Department of Planning and Environment

Our ref: OUT22/1959

Subject: **Moss Vale Plastics Recycling Facility (SSD-9409987) – Environmental Impact Statement (EIS)**

Detailed advice to DPE Planning & Assessment regarding the Moss Vale Plastics Recycling Facility (SSD-9409987) – EIS

Figure 3.1 presents the key measures relevant to all of the following sections.

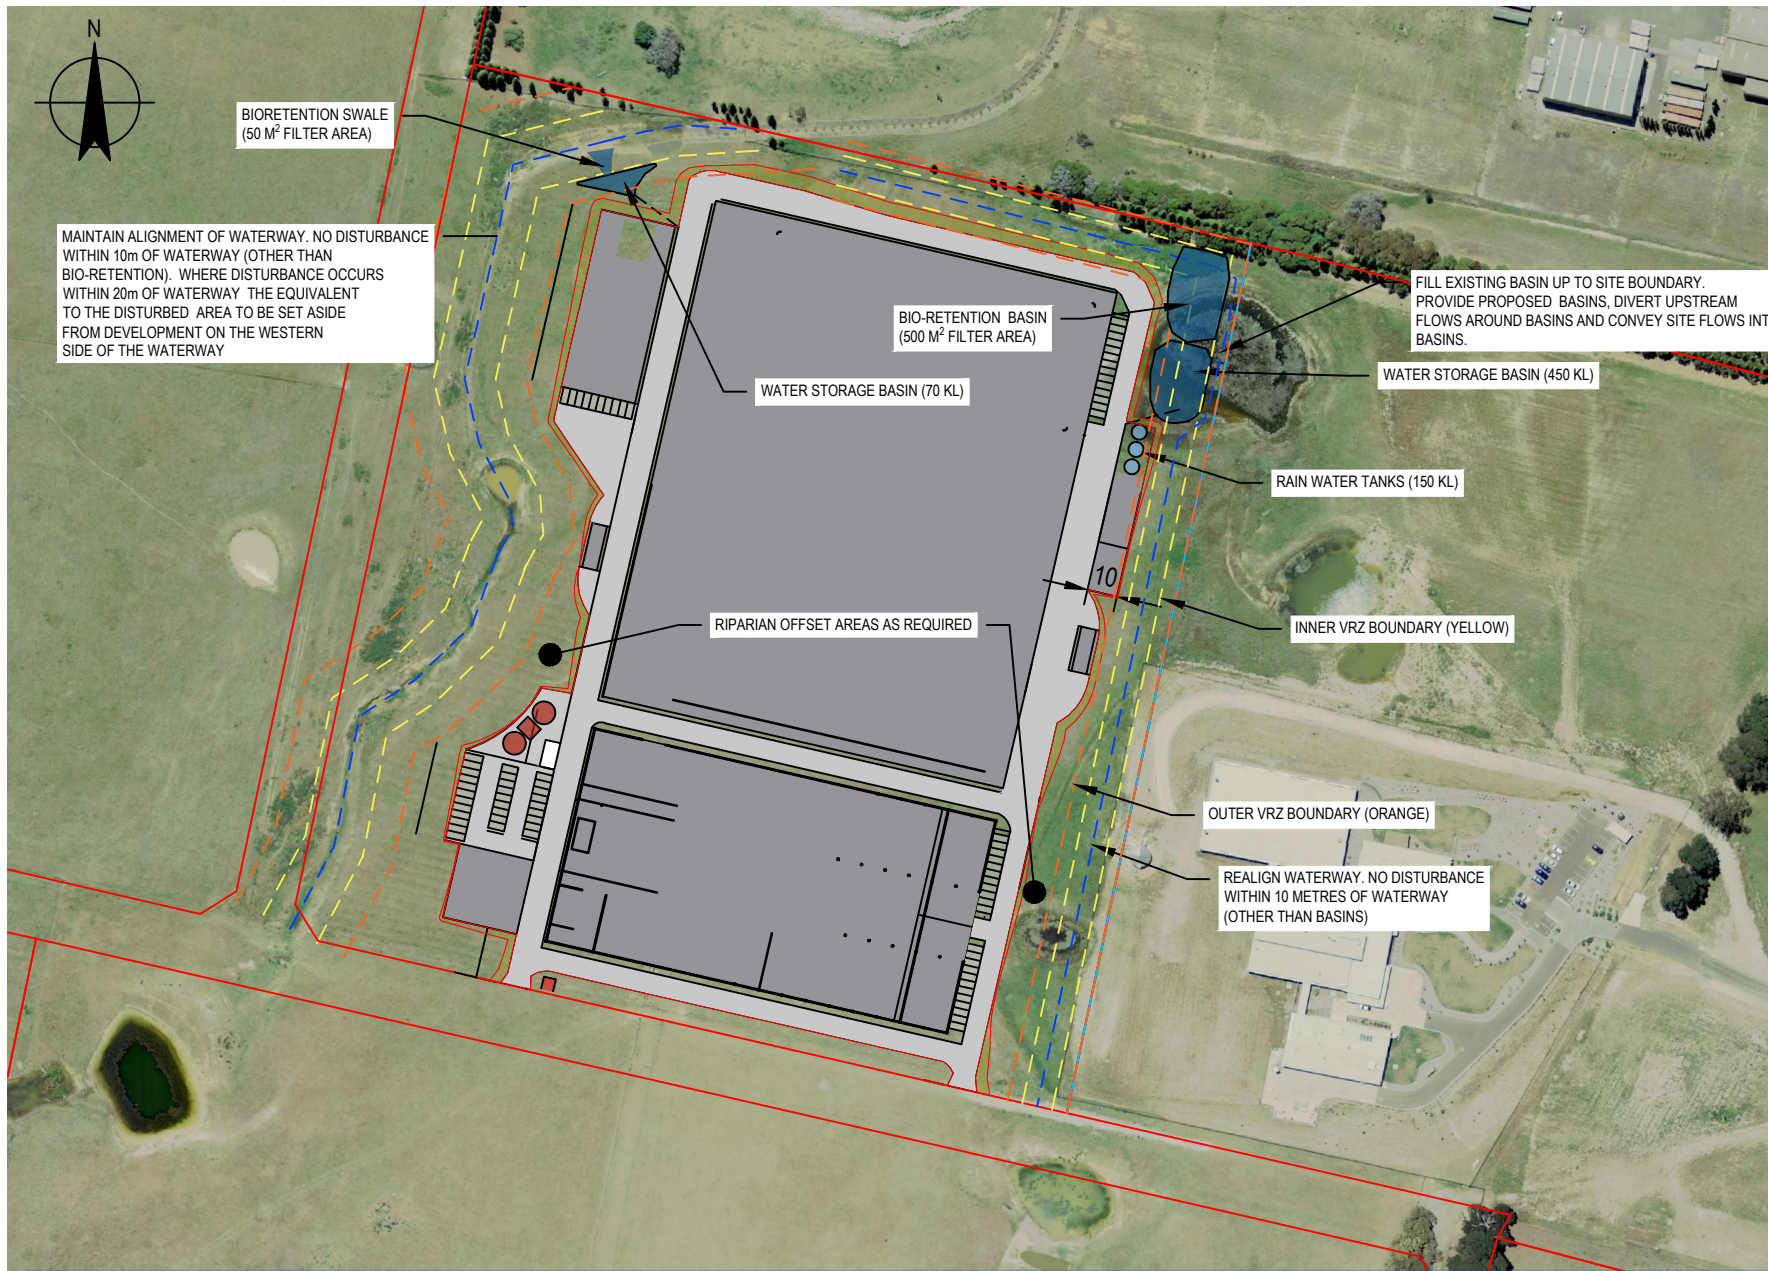
The proponent should provide detail on how the proposed water storage dams meet the requirements of the water regulatory framework. This needs to review the applicability of exemptions, harvestable rights or if water entitlements will be held to account for this take.

Clarification is requested on how the proposed storage dams meet the water regulatory framework. The dams will require a water licence unless an exemption applies such as under Schedule 1(3) of the *Water Management (General) Regulation 2018* or the dam capacity is within the Maximum Harvestable Rights Dam Capacity. More information on harvestable rights can be found at: <https://www.watarnsw.com.au/customer-service/water-licensing/blr/harvestable-rights-dams>
